Our reference: P-1201393-L2H1
Contact: Sandra Fagan
Telephone: (02) 4732 7992

**Council Advice on Environmental Impact Statement for SSD-99079487 –
SEED Stage 1B at 1669-1723 and 1669A Elizabeth Drive, Badgerys Creek**

Thank you for providing Penrith City Council the opportunity to comment on the subject Environmental Impact Statement (EIS) relating to Stage 1B of the proposed Mirvac SEED industrial estate.

Figure 3-7: Site Plan (Warehouse 8)

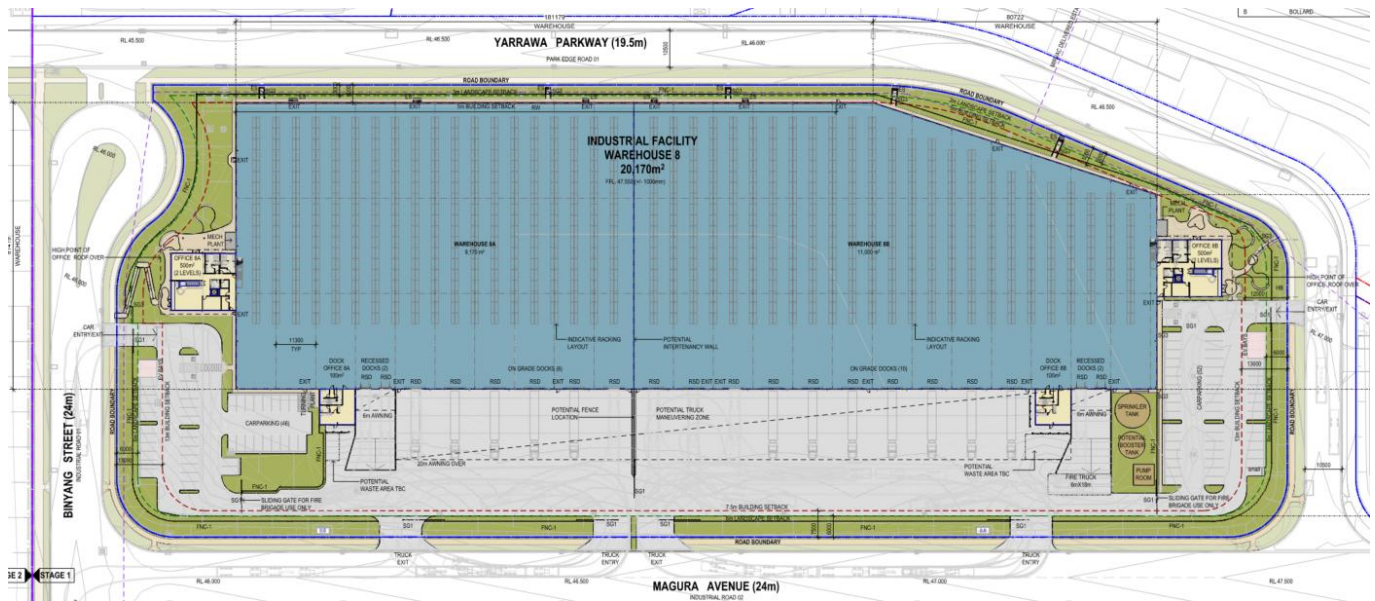
- h) Notwithstanding previous comments, it still appears that Warehouse 8 turns its back to the adjoining ENZ zoned land. The eastern facade of Warehouse 8, although incorporating a splay, is a long continuous facade in a mostly single plane.
